Our ref: HA/2021/123006/01-L01
Your ref: AB/14/21/HH
Date: 24 March 2021

REINSTATEMENT OF TIMBER JETTY USING EXISTING 3 PILES

RIVERSIDE HOUSE 2 FITZALAN ROAD ARUNDEL BN18 9JS

**JETTY
EXISTING AND PROPOSED LAYOUT PLAN**

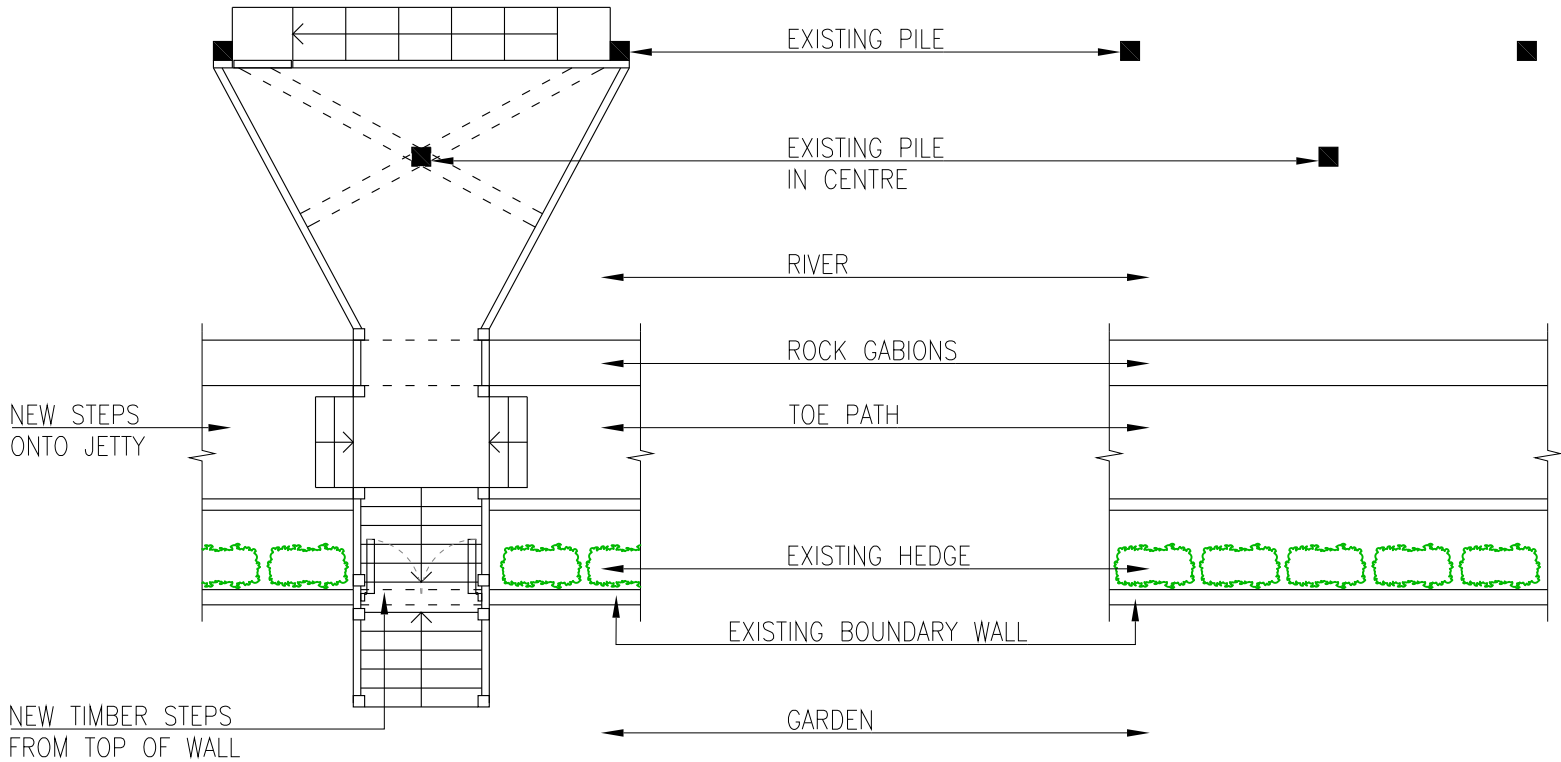
- The proposed design has the potential to affect future maintenance/access to the flood defence in this location due to the narrowed path. How is it proposed to mitigate this risk?

JETTY
PROPOSED SITE LAYOUT

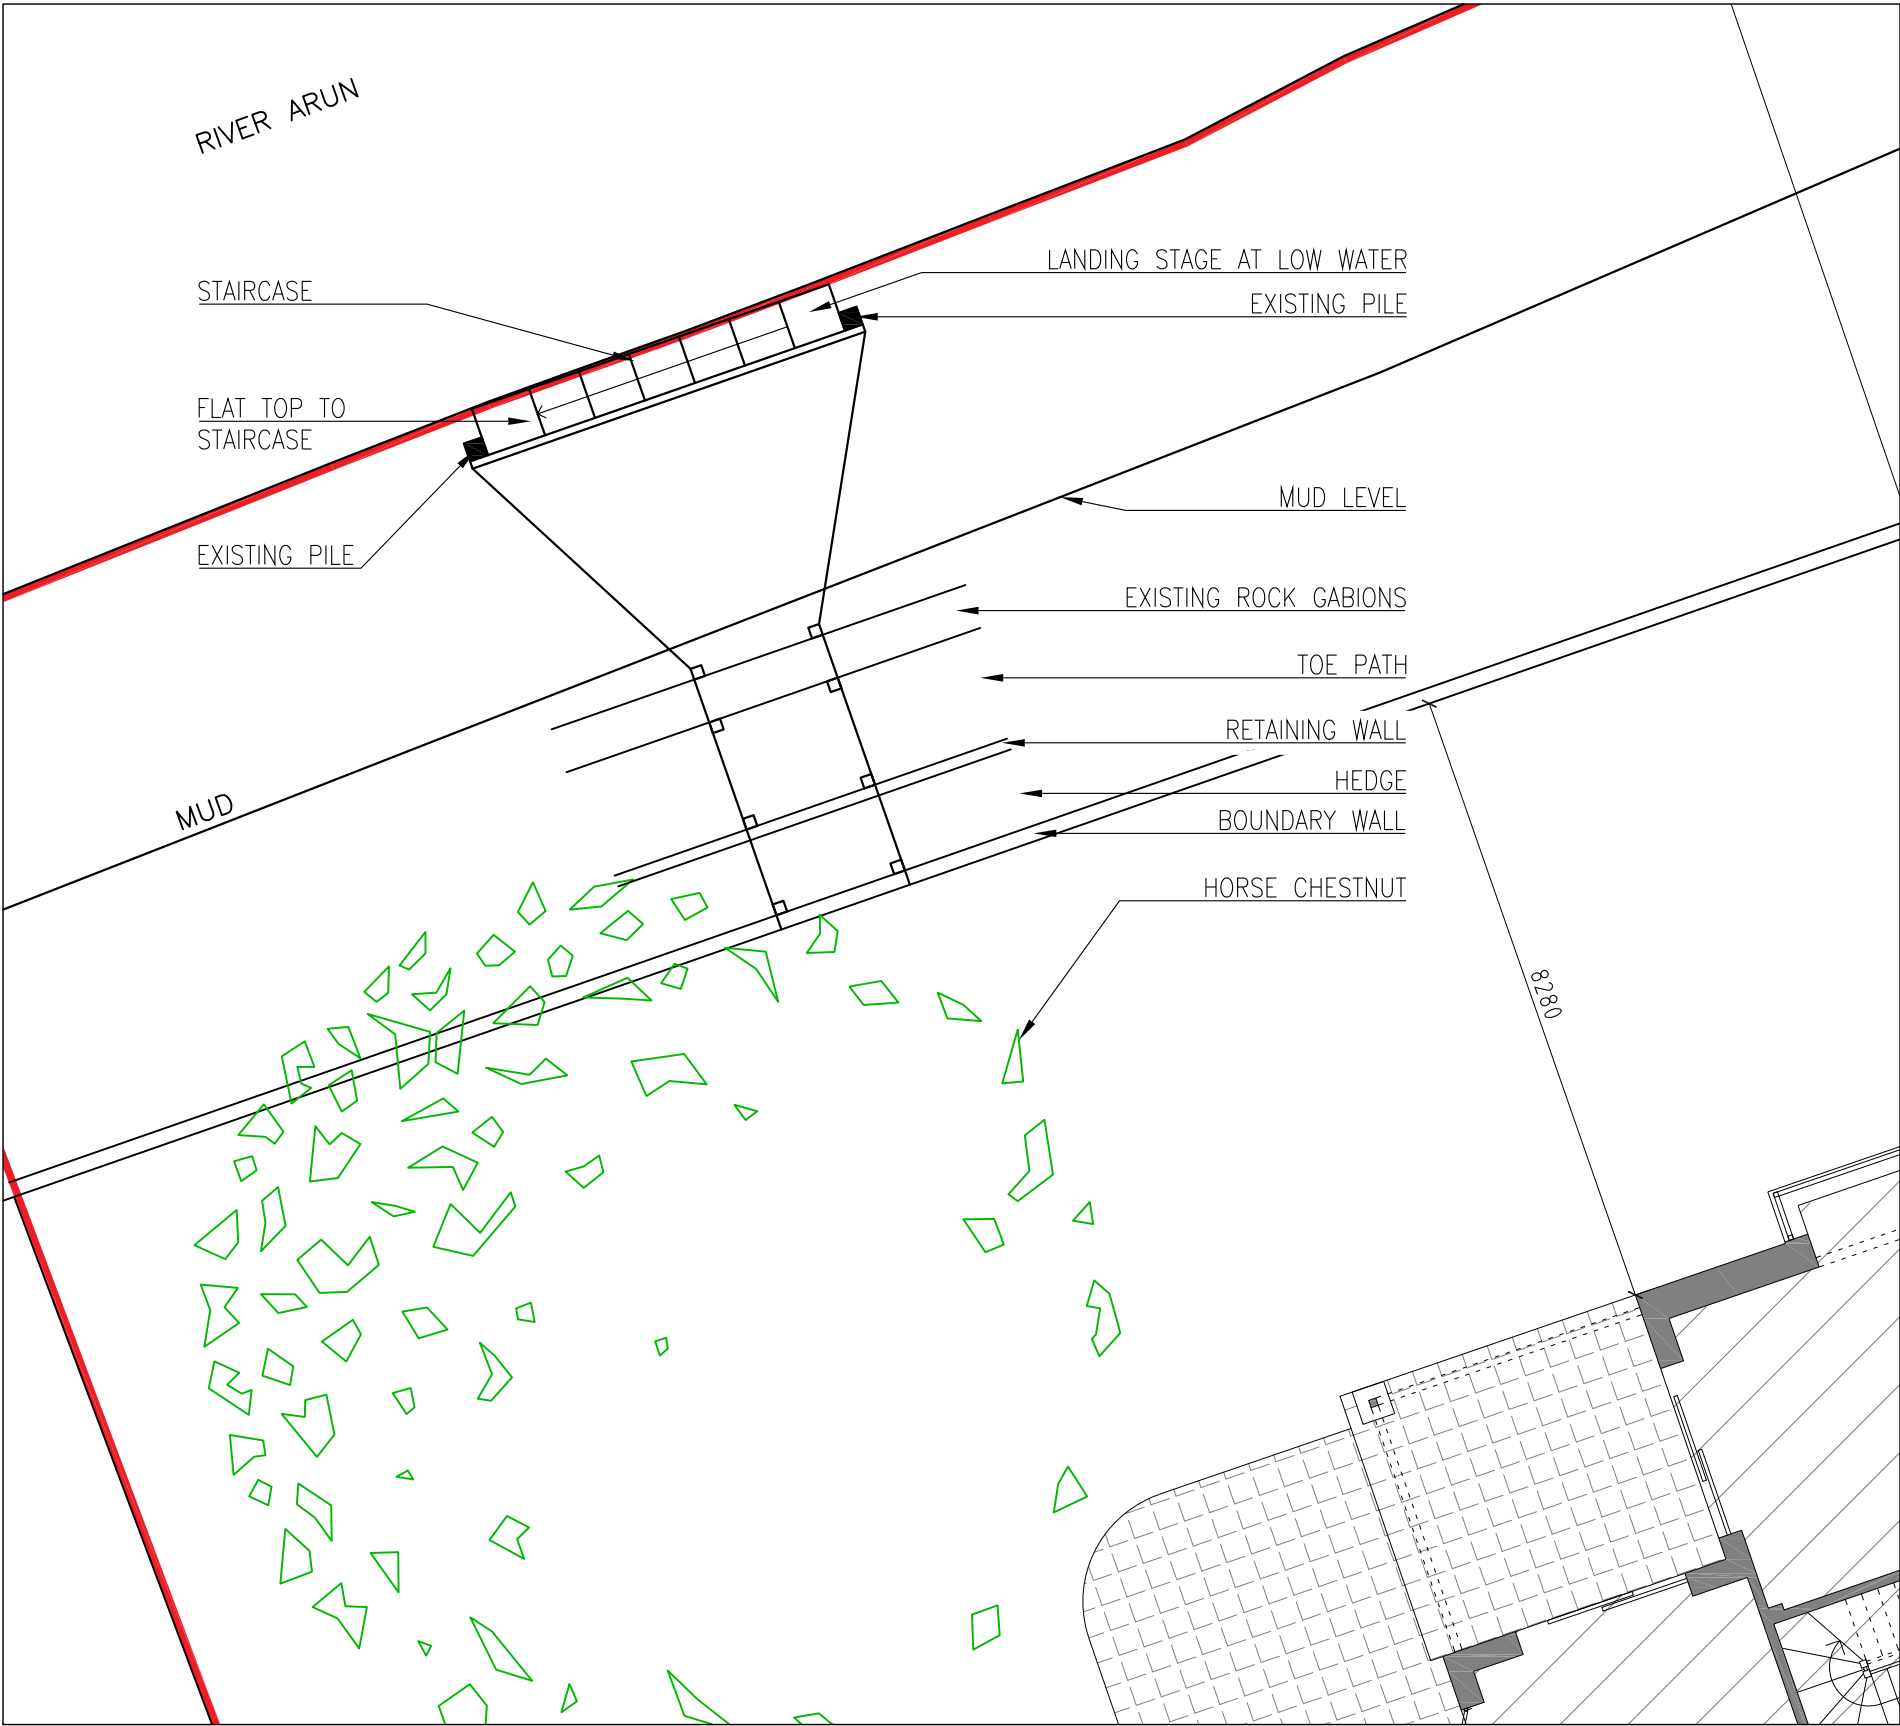
- The steps and new timber structure could collect debris at high tides/flows, increasing the load on the structure. Has this been considered in the structural calculations? Please provide evidence.

JETTY
PROPOSED EAST AND WEST ELEVATIONS

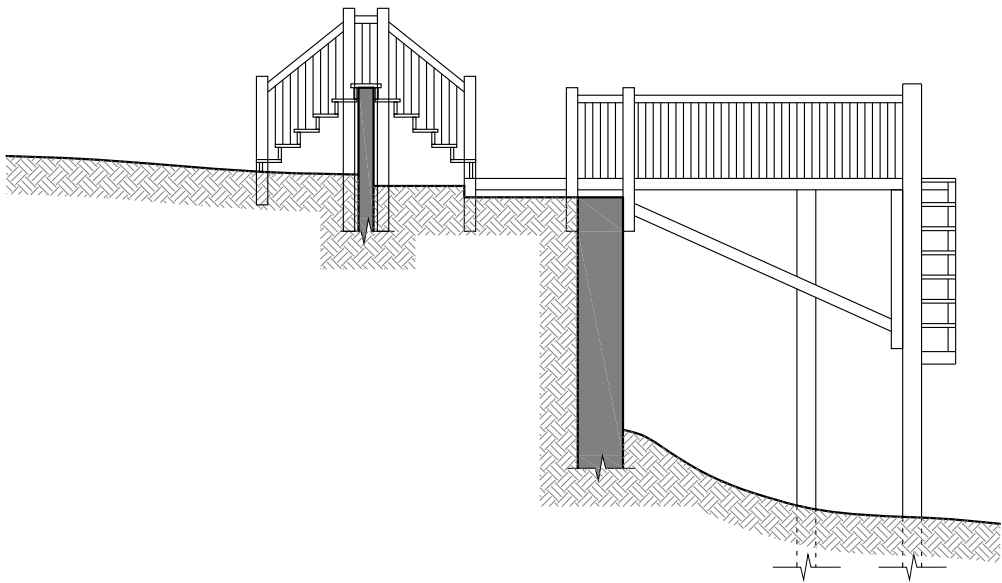
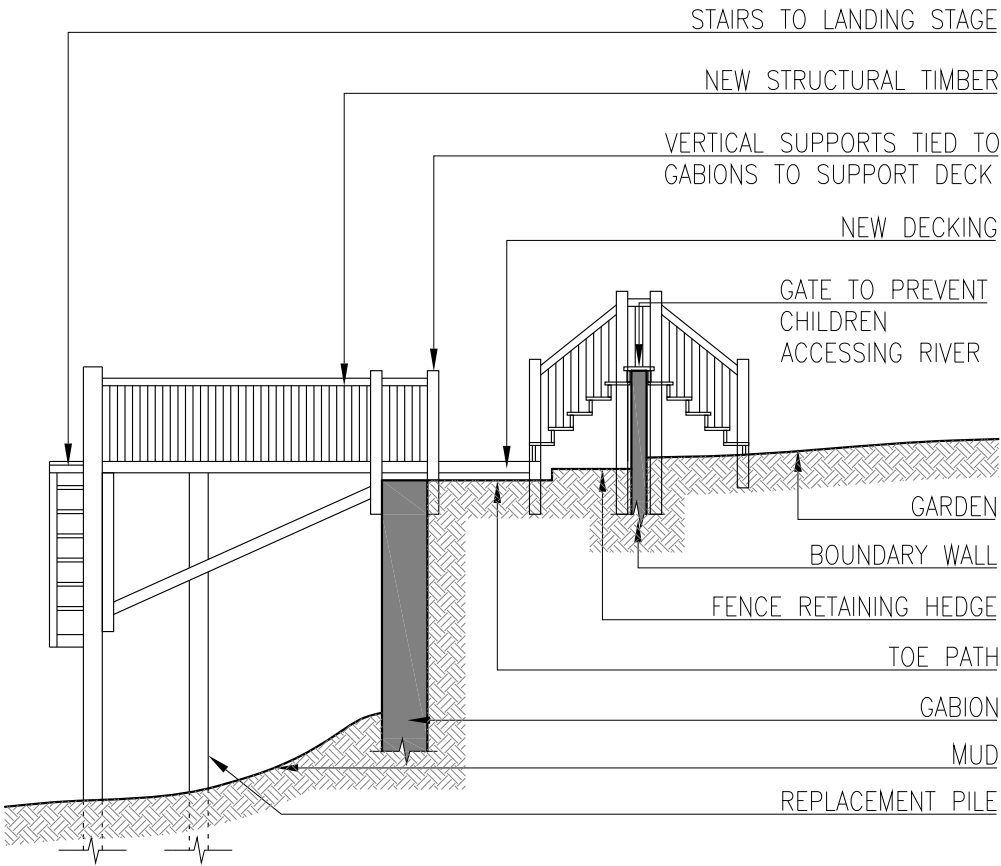
- Vertical supports are tied to the existing gabions to support the deck, and there also seems to be a timber support strut tied to the gabion wall. The gabions wouldn't have been designed for additional loading. What damage would be done to the gabions if this structure failed? Has this been considered as part of the structural design? Please provide evidence.

- Would the low landing stage and steps to the landing stage, be fully submerged at high water becoming a hidden underwater obstacle?
- With regards to the structural stability of the replacement pile, is this a key structural element in the design and can it be driven to a sufficient depth to provide the loading requirements, considering the known soft ground conditions in the area? Please provide evidence.
